Planning Inspectorate

Our ref: XA/2026/100531/01-L01

**ENVIRONMENT AGENCY RELEVANT REPRESENTATION. THE DROVES
SOLAR FARM, EAST ANGLIA.**

Drawing file: published-documents / EN0110013-000144-6.3 ES Figure 12.13 Work No.2 Piling Locations within CSA for Maximum Groundwater Level.pdf

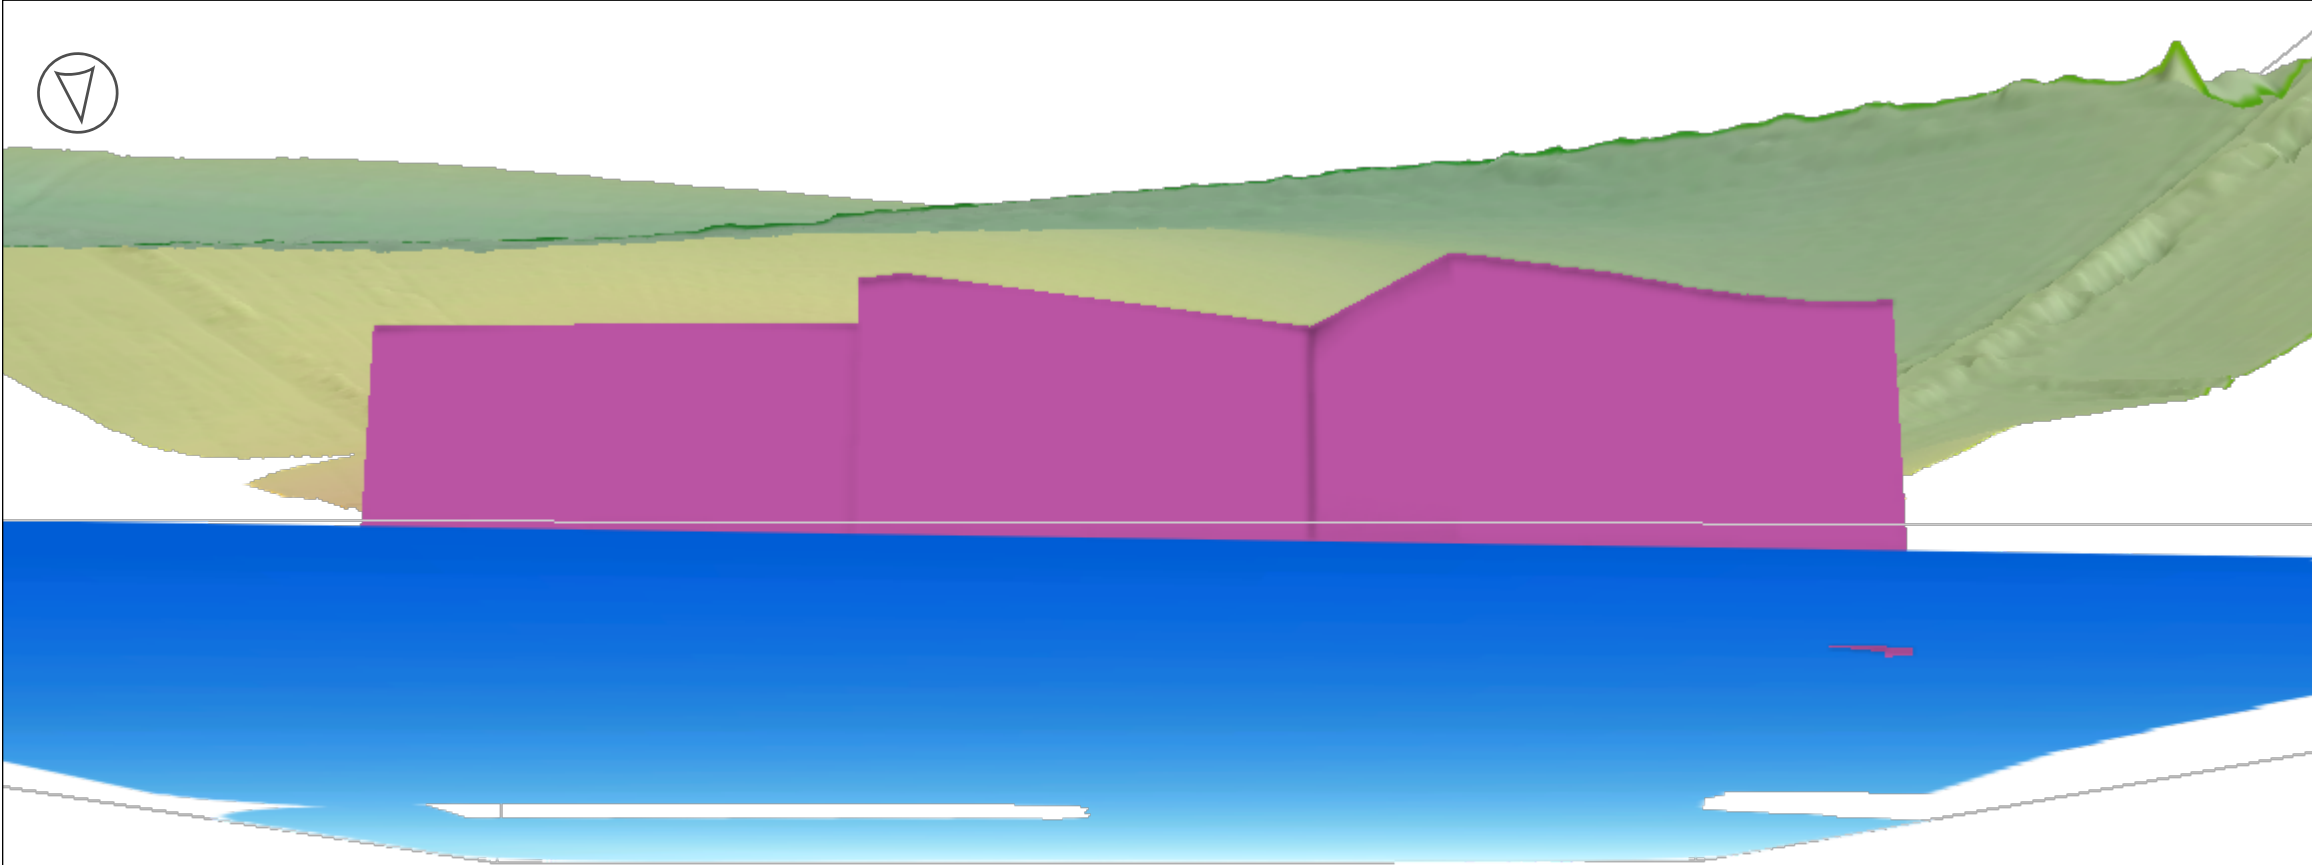
ID: EA05 (Maximum Foundation Extents)		
<p>Figure 12.13 Work No.2 Piling Locations within CSA for Maximum Groundwater Level [APP-127]</p>	<p>Issue:</p>	<p>Figures 12.13 to 12.16 do not clearly show the orientation of each 3D model view, and the elevation of the maximum extent of foundations is not given.</p>
	<p>Impact:</p>	<p>Difficulty in interpreting figures.</p>
<p>Figure 12.14 Work. No 3 Piling Locations within</p>	<p>Solution:</p>	<p>Revise figures to more clearly define the area represented in the drawings, including view orientation, and the maximum foundations extent should be shaded to show elevation values. The model should be updated to inform detailed foundation design, based on site specific survey and monitoring data.</p>

DRAWING TITLE:
ES Figure 12.15 Work No. 4 Piling Locations within
CSA for Maximum Groundwater Level

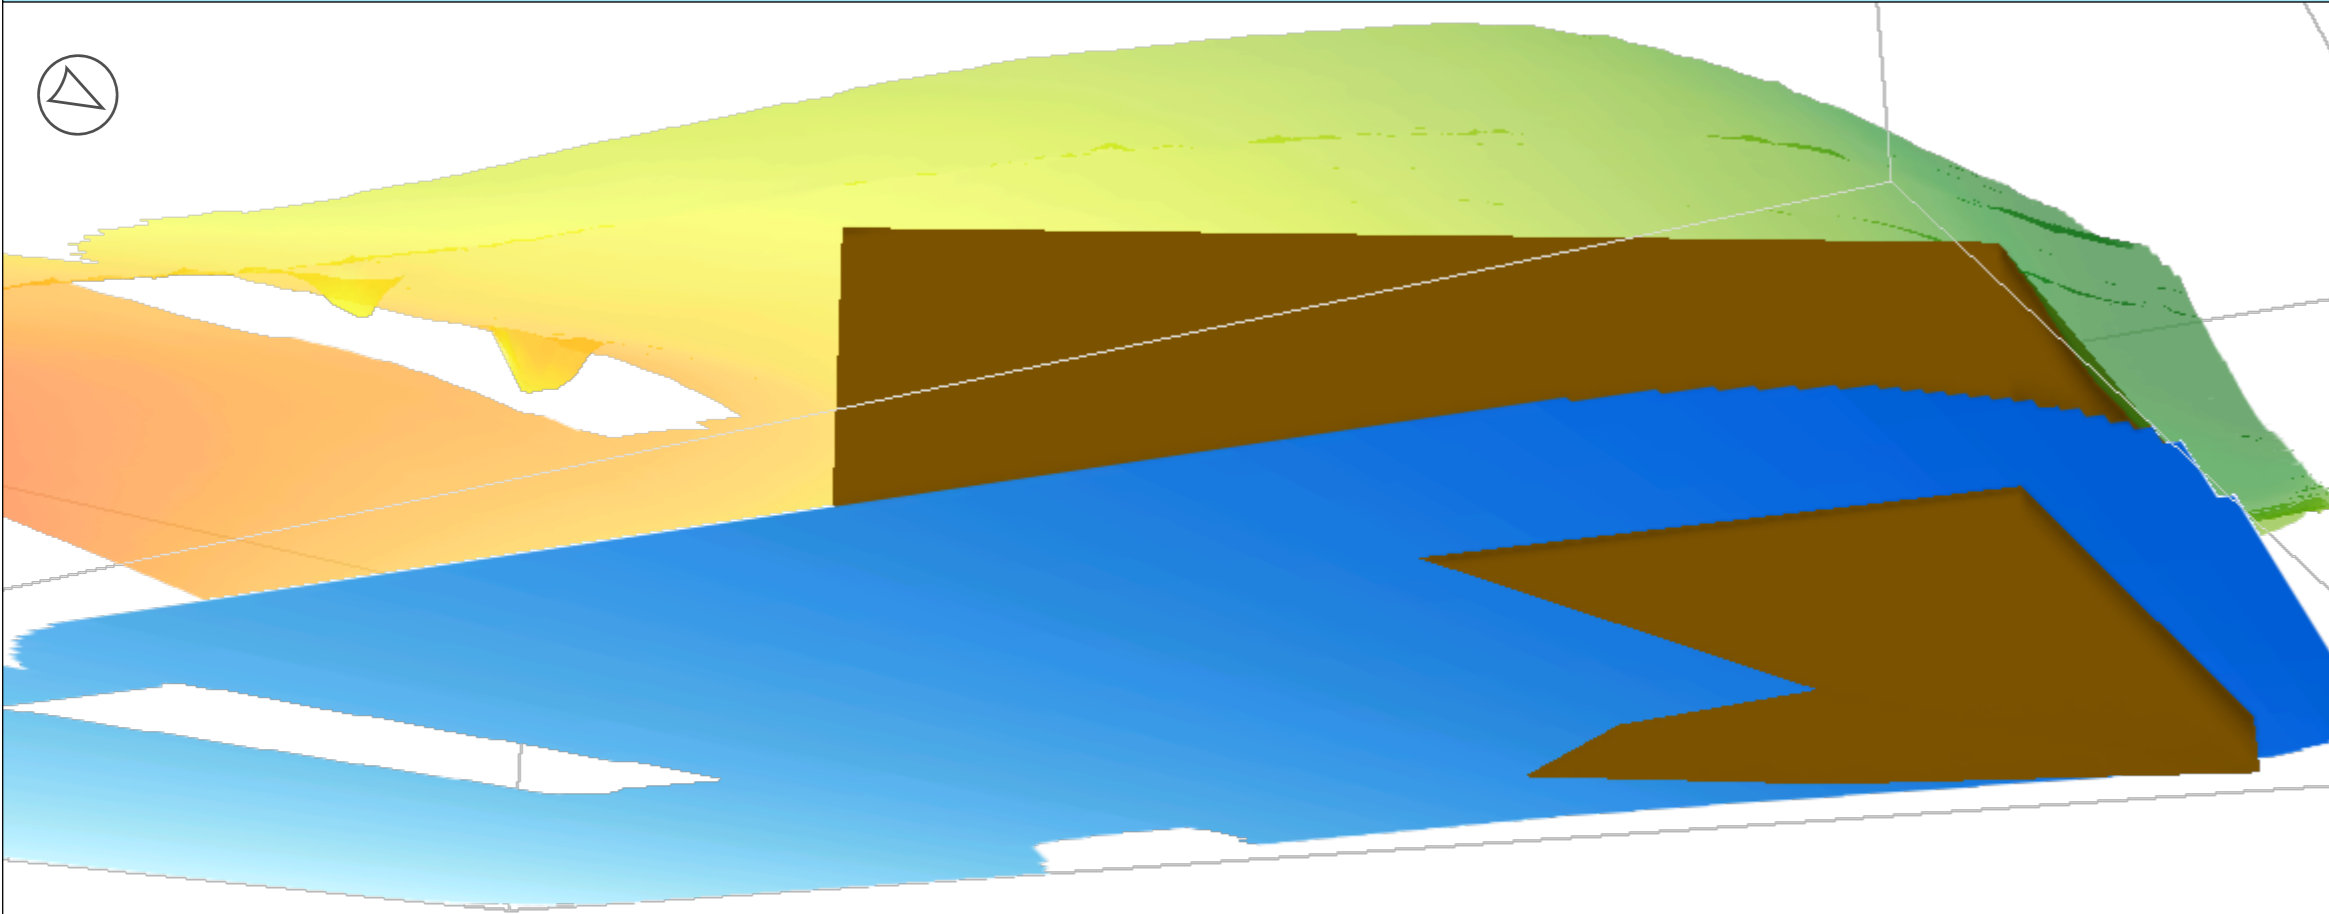
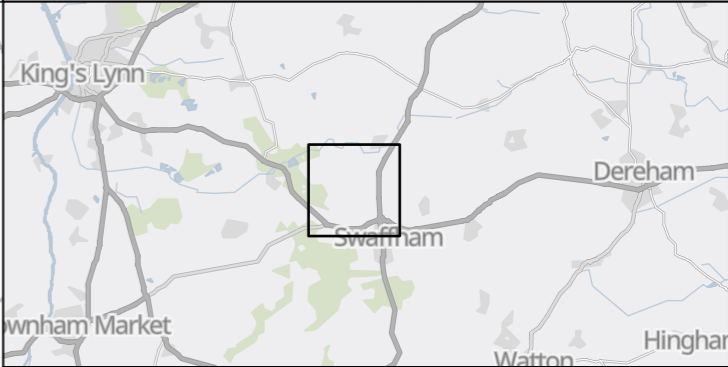
<p>CSA for Maximum Groundwater Level [APP-128]</p> <p>Figure 12.15 Work No. 4 Piling Locations within CSA for Maximum Groundwater Level [APP-129]</p> <p>Figure 12.16 Maximum Foundation Extents for Minimum Groundwater Level [APP-130]</p>		
<p>Additional comments:</p>	<p>Use of inconsistent terminology may also result in confusion. Figures 12.13 to 12.15 are titled to show the anticipated extent of piling in comparison with the maximum groundwater level. In the context of the data presented, the maximum groundwater level in mAOD represents the shallowest extent and therefore worst-case condition for groundwater. For clarity the report should preferably refer to groundwater 'elevation' (in mAOD) as is represented within the figures rather than 'level', which could be misinterpreted as relative to ground level rather than Ordnance Datum.</p> <p>Figure 12.16 shows the minimum (i.e. deepest) groundwater elevation (i.e. best case) in relation to anticipated piling depth. Although this is useful information, this could potentially be misinterpreted by the reader as presenting a combined overview of the information provided in Figures 12.13 to 12.15.</p>

Drawing file: published-documents / EN0110013-000634-6.3.1 ES Figure 12.10 Groundwater Flow Directions from NEAC Groundwater Model.pdf

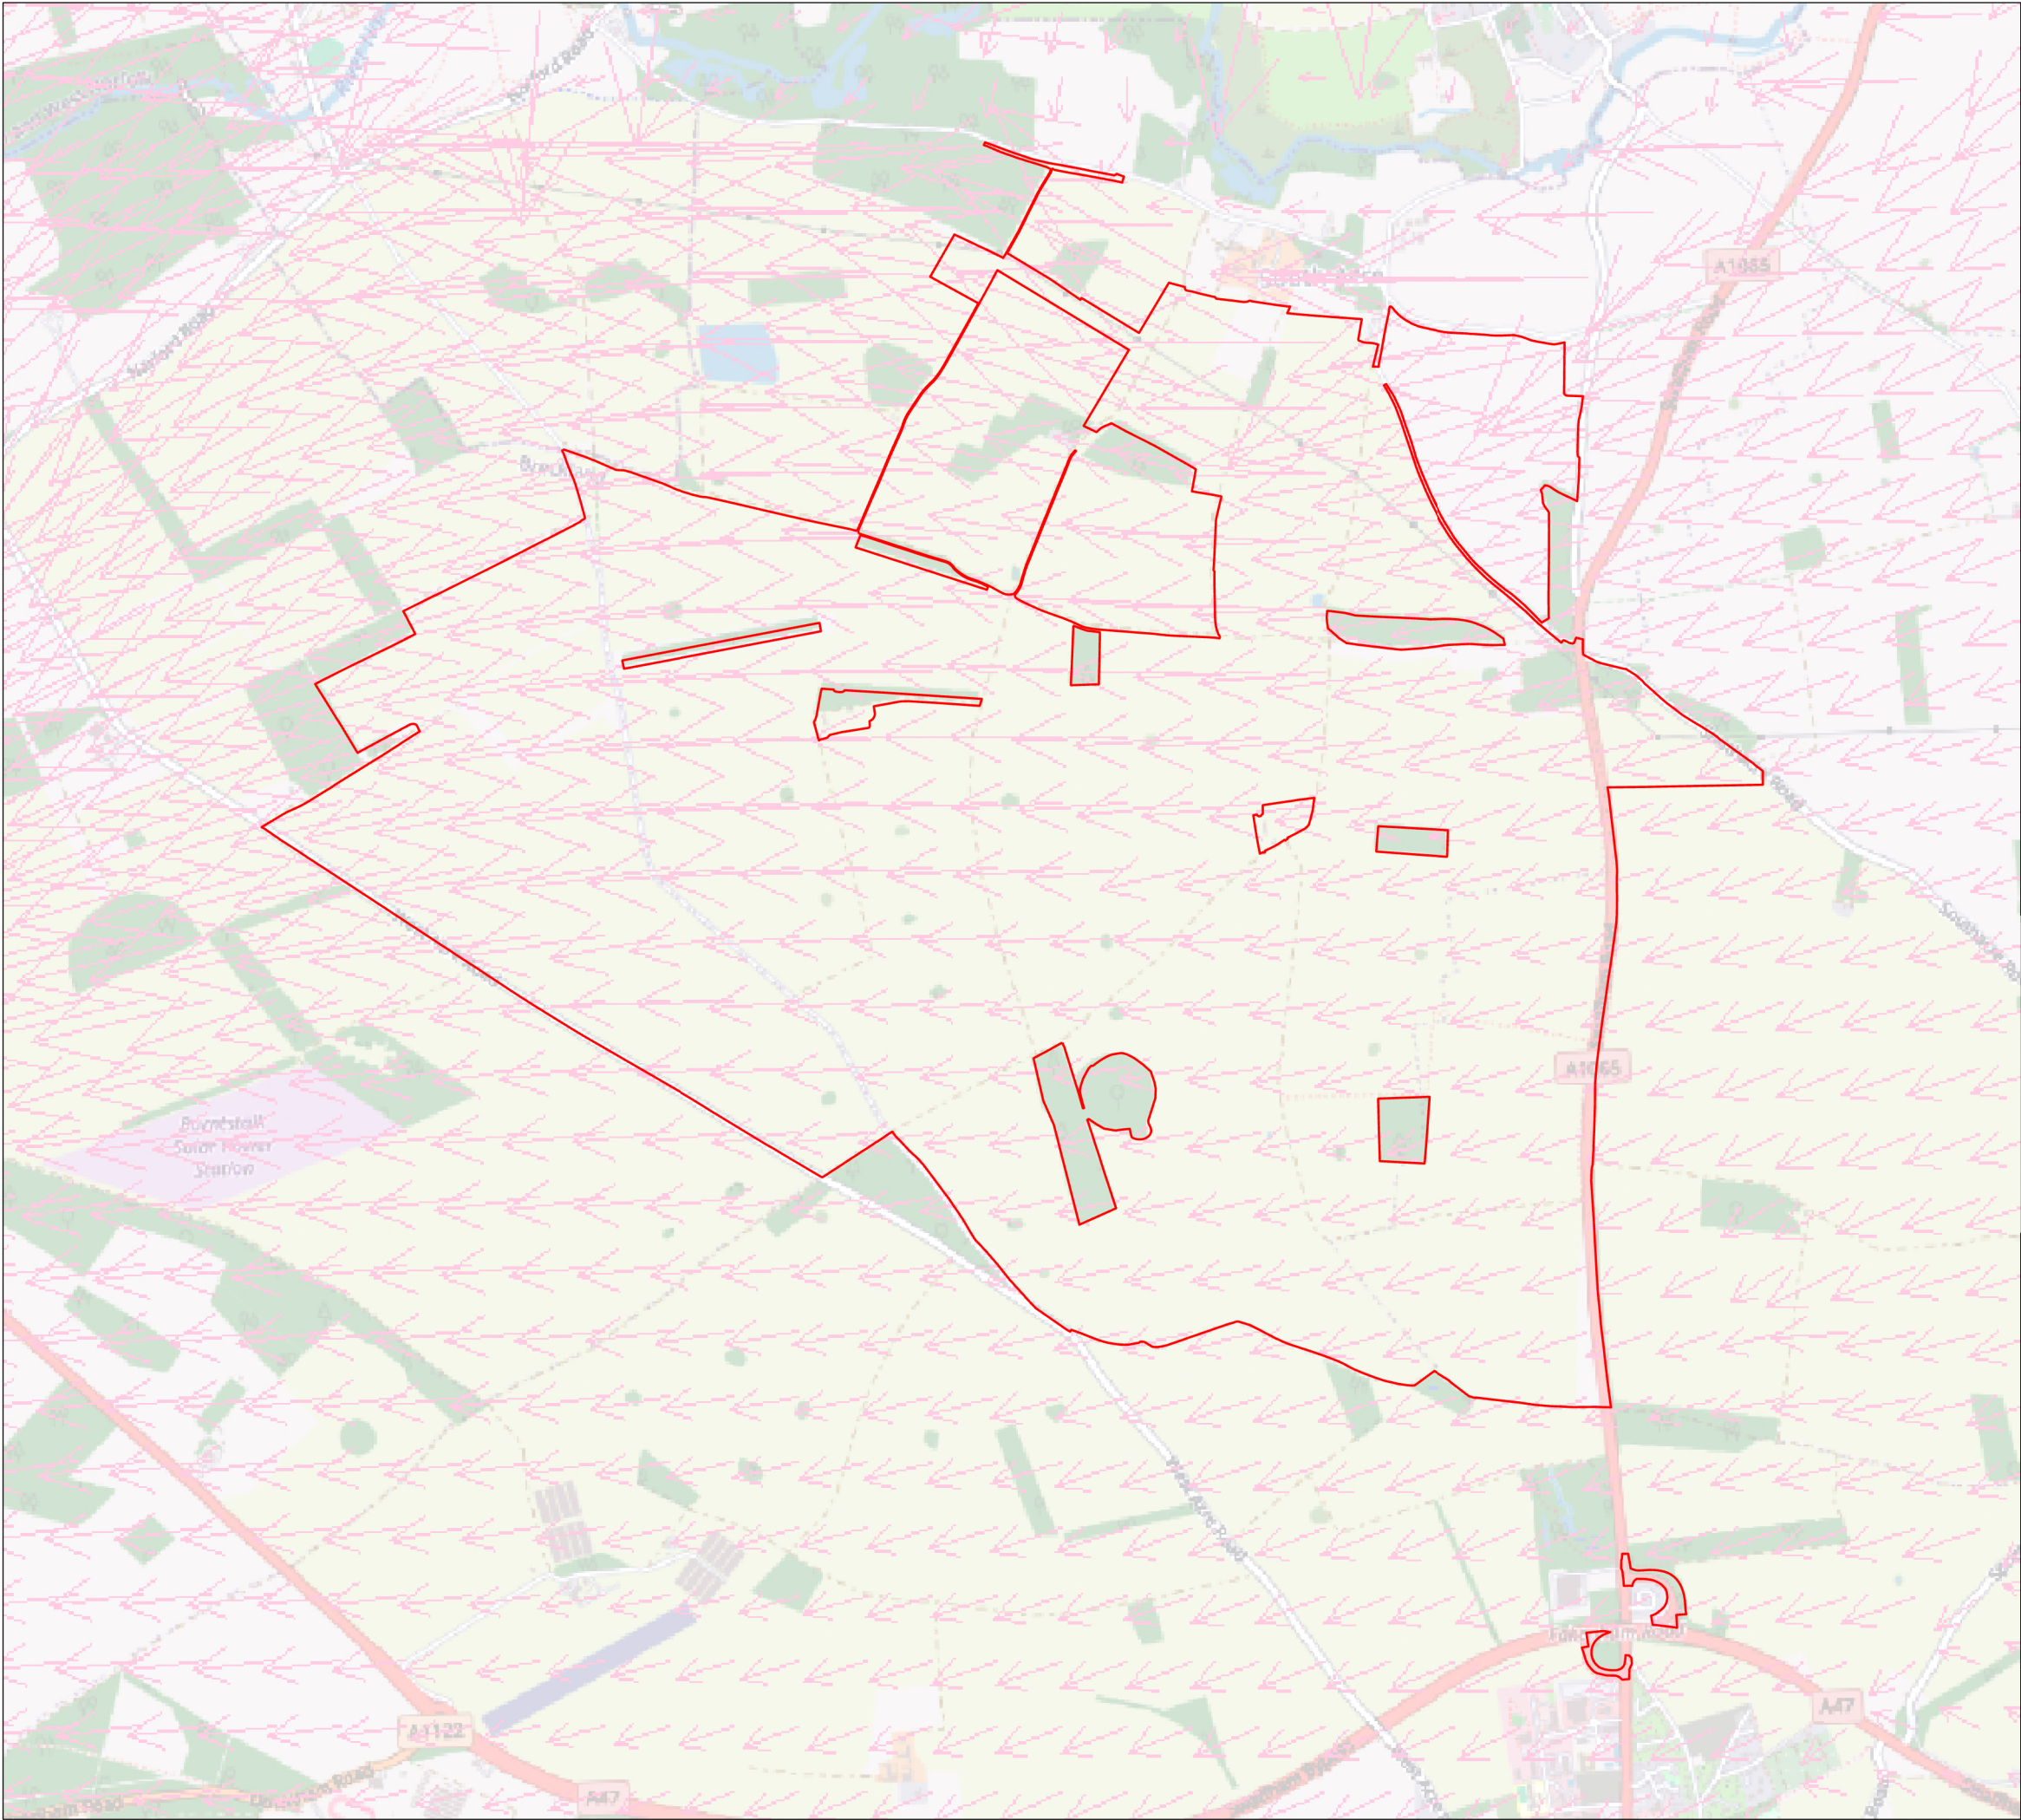
<p>ID: EA04 (Groundwater Flow Direction)</p>		
<p>Figure 12.7 3D Representation of Groundwater [APP-121]</p>	<p>Issue:</p>	<p>Estimated groundwater flow direction across most of the draft Order Limits area is indicated to be toward the north-east, north or northwest, approximately following local topography.</p>
<p>Figure 12.8 Minimum Static Groundwater Level Depths within CSA [APP-122]</p>	<p>Impact:</p>	<p>Groundwater flow direction as indicated in Figures 12.7 to 12.16 may be inaccurate.</p>
<p>Figure 12.9 Maximum Static Groundwater Level Depths within CSA [APP-123]</p>	<p>Solution:</p>	<p>Claims such as that made in Sections 12.6.37 and 12.6.38 regarding potential groundwater interception should be revised and new evidence, preferably across multiple lines, sought to support them. Intrusive investigation to measures groundwater level with empirical evidence is highly recommended.</p>
<p>Figure 12.10 Groundwater Flow Patterns [APP-124]</p>

<p>the potentiometric groundwater upper surface within the Chalk principal aquifer in the vicinity of the site is locally northward toward the River Nar valley but more generally toward the west in the direction of the Marham public water supply abstraction. This is shown in the BGS map as ranging from approximately 30m Above Ordnance Datum (AOD) in the east to approximately 15m AOD in the west.</p> <p>The model outputs produced by the Applicant can be compared to the outputs for various hydrological scenarios available from the Environment Agency’s North East Anglian Chalk (NEAC) model, a bespoke groundwater model using MODFLOW 5 which covers most of East Anglia.</p> <p>The outputs for a wet month Scenario (March 2001 – corresponding to the Applicant’s ‘worst-case’ data usage of highest recorded levels) show very different groundwater contours and resultant flow directions compared with those produced by the Applicant. Flow in the Chalk is east-to-west in the NEAC model data, rather than south-to-north using the Applicant’s techniques derived from individual boreholes nearby. Northwards flow is present locally near the left bank of the Nar, but this reflects the topography close to the Nar intercepting the westerly flowing groundwater. If modelling will be used in the future, the Applicant is advised to consider groundwater flow on a more regional level rather than overfitting a model to a low number of interpolated datapoints. They may also choose to request model runs done on the Environment Agency’s NEAC model which can run scenarios designed and paid for by the Applicant.</p> <p>Although the Applicant’s estimations are within a similar range of values for most of the Study Area, the figures provided from their modelling should not be accepted as an accurate representation of subsurface groundwater elevation or flow direction.</p>
